DECISION DELEGATED TO HEAD OF PLANNING

Application No:	H17-0162-22	Applicant:	R T W Construction & Developments Ltd
Proposal:	Details of boundary treatments, management plan for areas of publicly accessible open space & outdoor play areas, swift bricks/boxes, external materials, construction management plan & method statement, details of precautions to be taken to prevent mud deposits on public highways and lighting design (Conditions 4, 5, 8, 9, 13, 14 & 16 of H17-0236-20)		
Location:	Land To The West Of Coalbeach Lane South Surfleet Spalding		
Terminal Date:	6th May 2022

Details of boundary treatments, management plan for areas of publicly accessible open space & outdoor play areas, swift bricks/boxes, external materials, construction management plan & method statement and details of precautions to be taken to prevent mud deposits on public highways (Conditions 4, 5, 8, 9, 13 & 14 of H17-0236-20)

DRAWING Site Sections

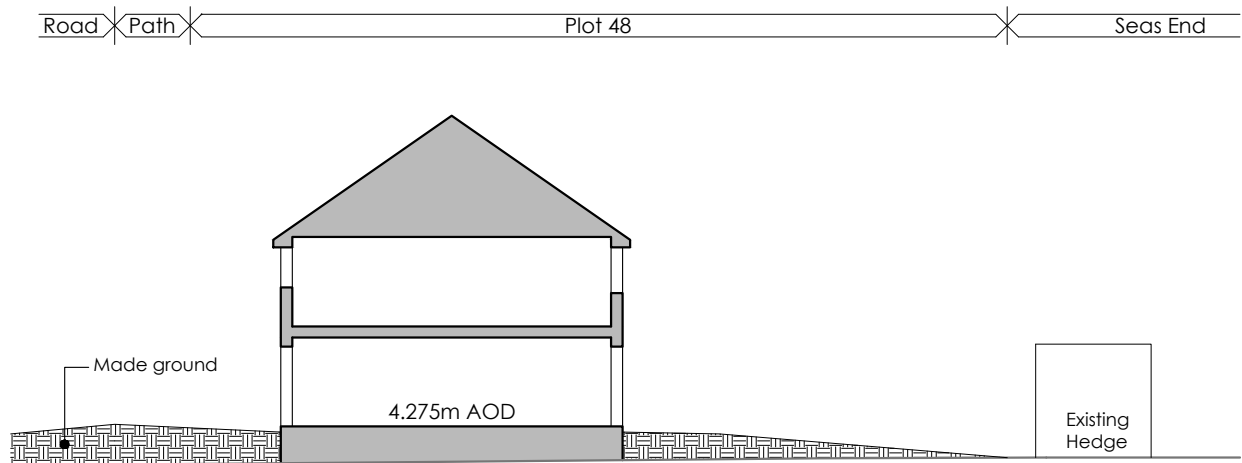
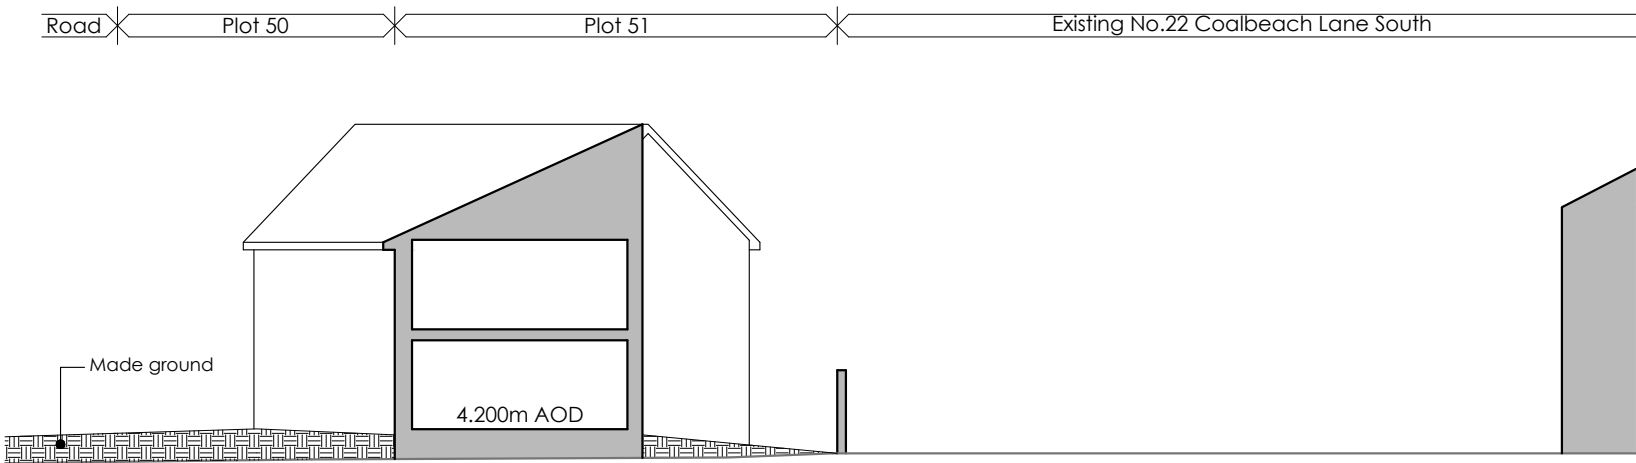
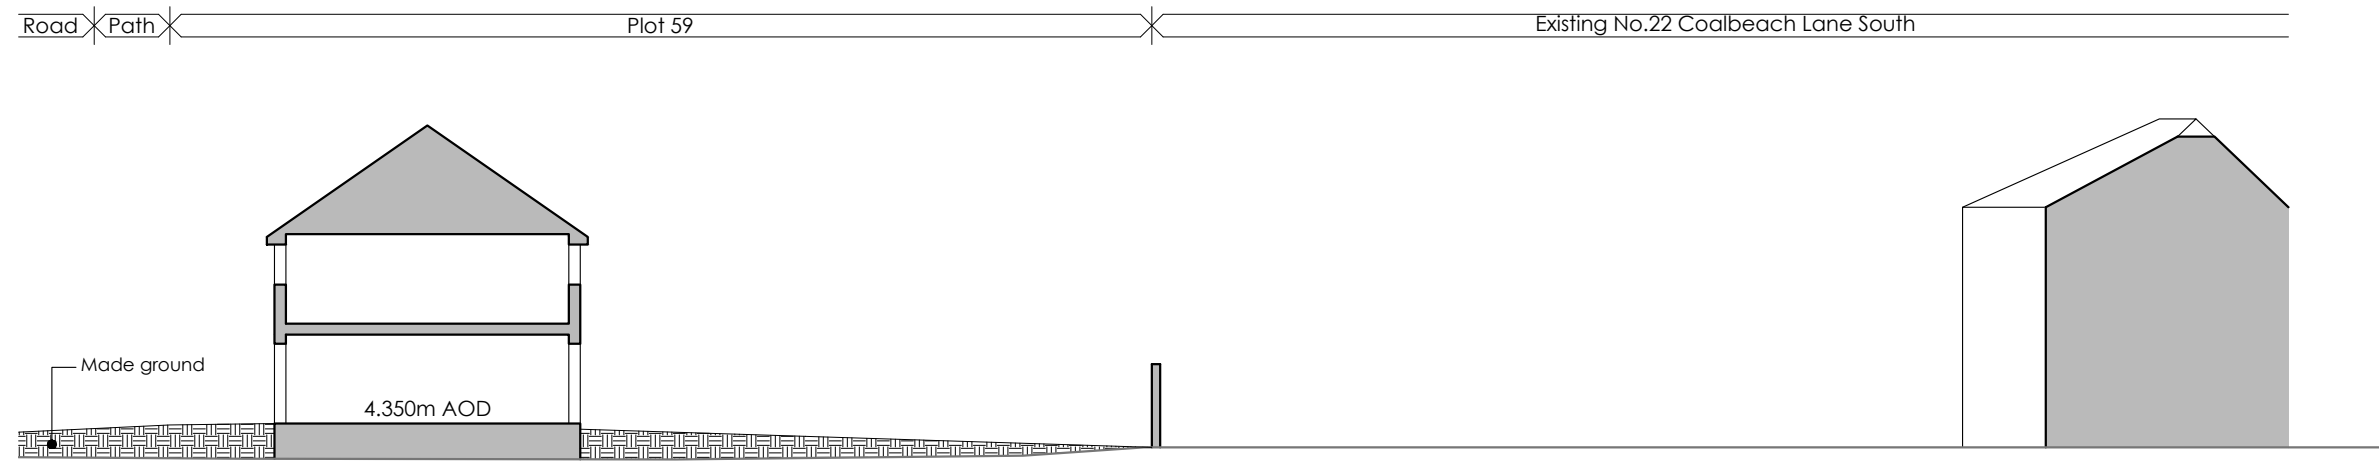
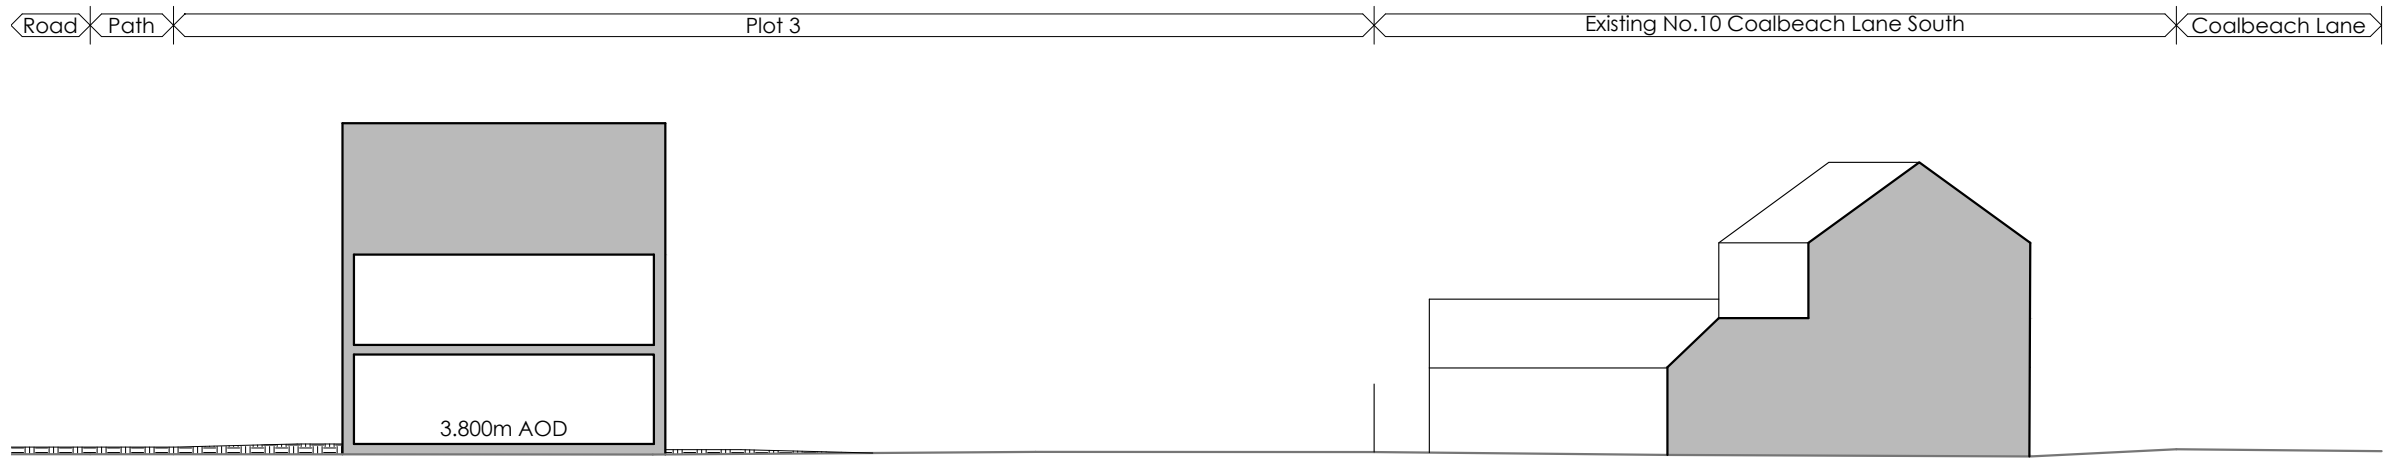
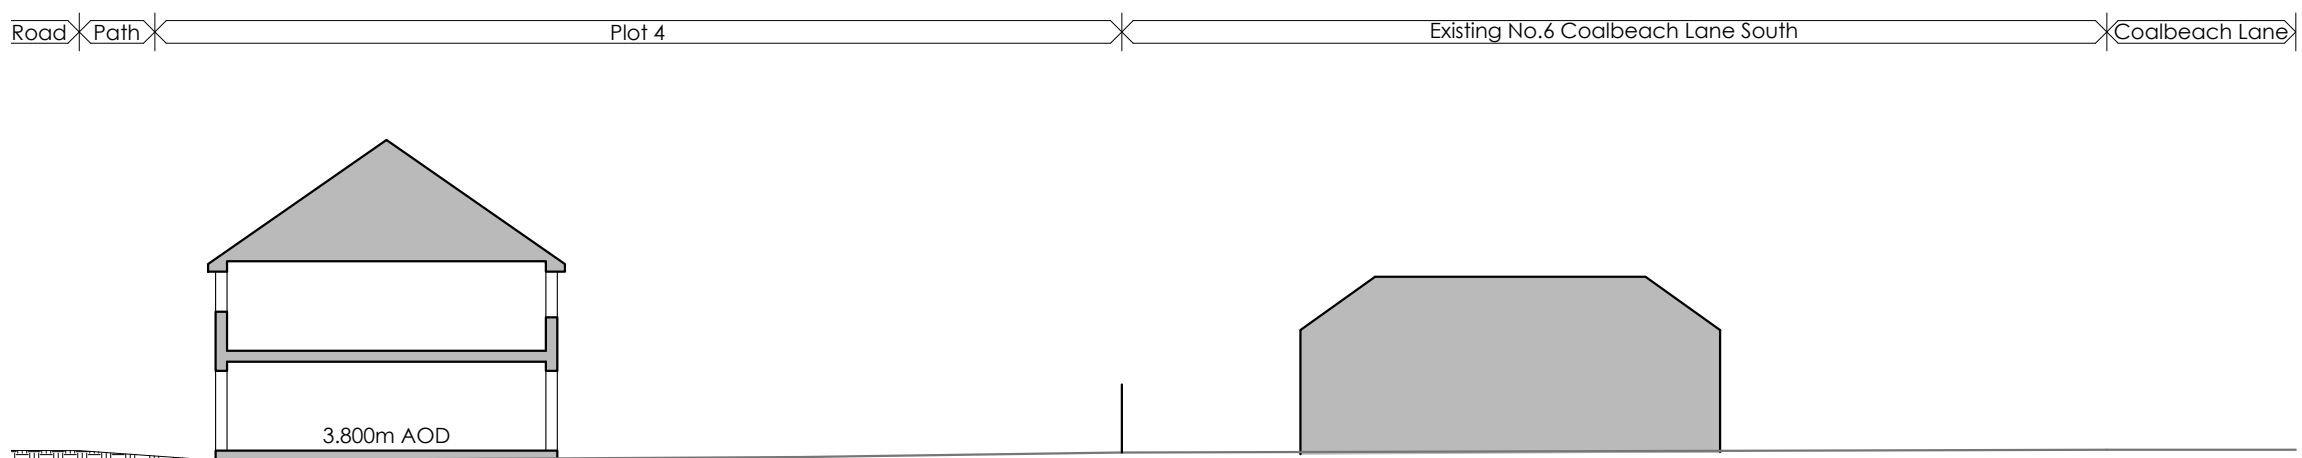
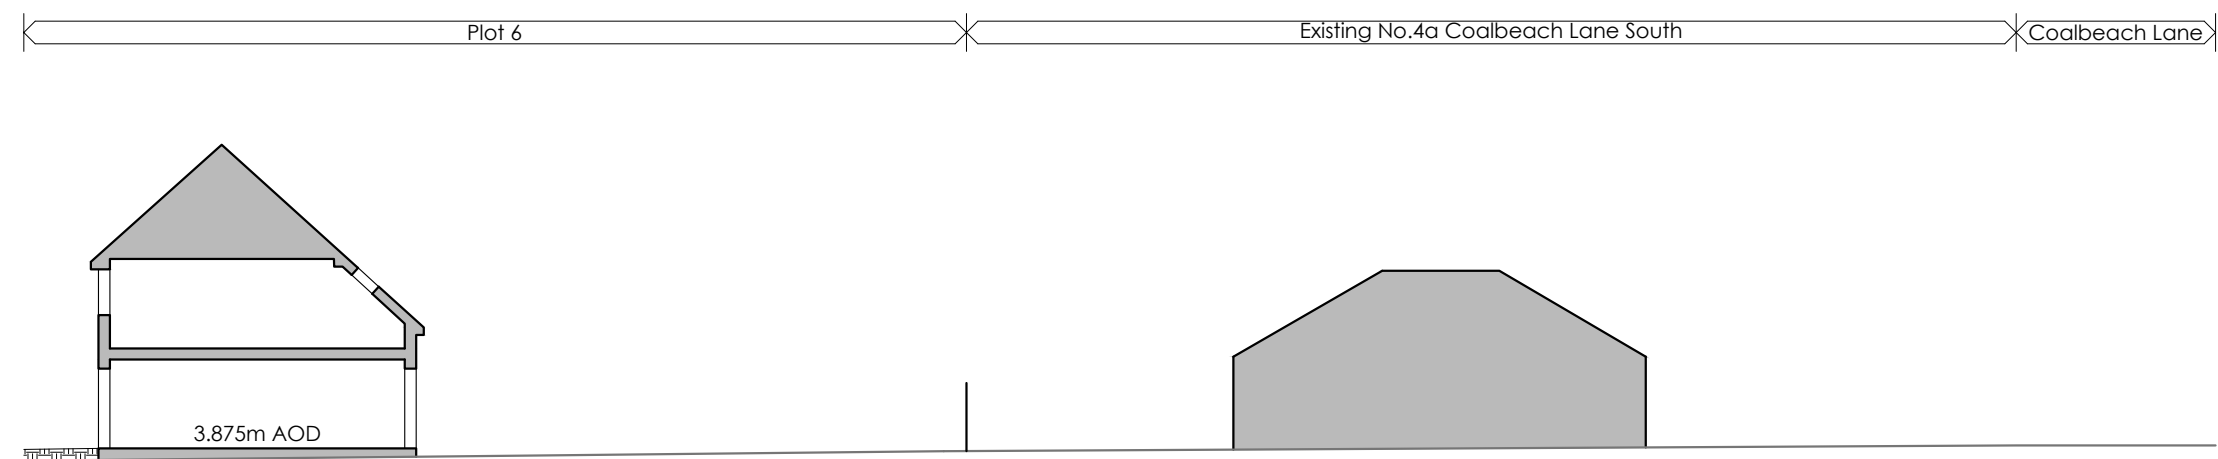
Note: Where levels are raised above existing ground levels, the submission shall be supported by cross-sectional drawings showing the relationship with adjoining uses and buildings to enable the Local Planning Authority to be satisfied that sufficient mitigation measures will be in place.

The revised plan has addressed an issue raised by a resident of Station Road dating back to the original application, in that it now provides fencing along one side of the footpath link to Station Road. Cross sections have been submitted and these indicate that 1.8m high fencing along boundaries with existing properties are adequate to protect residential amenity as there is not a significant difference in levels.
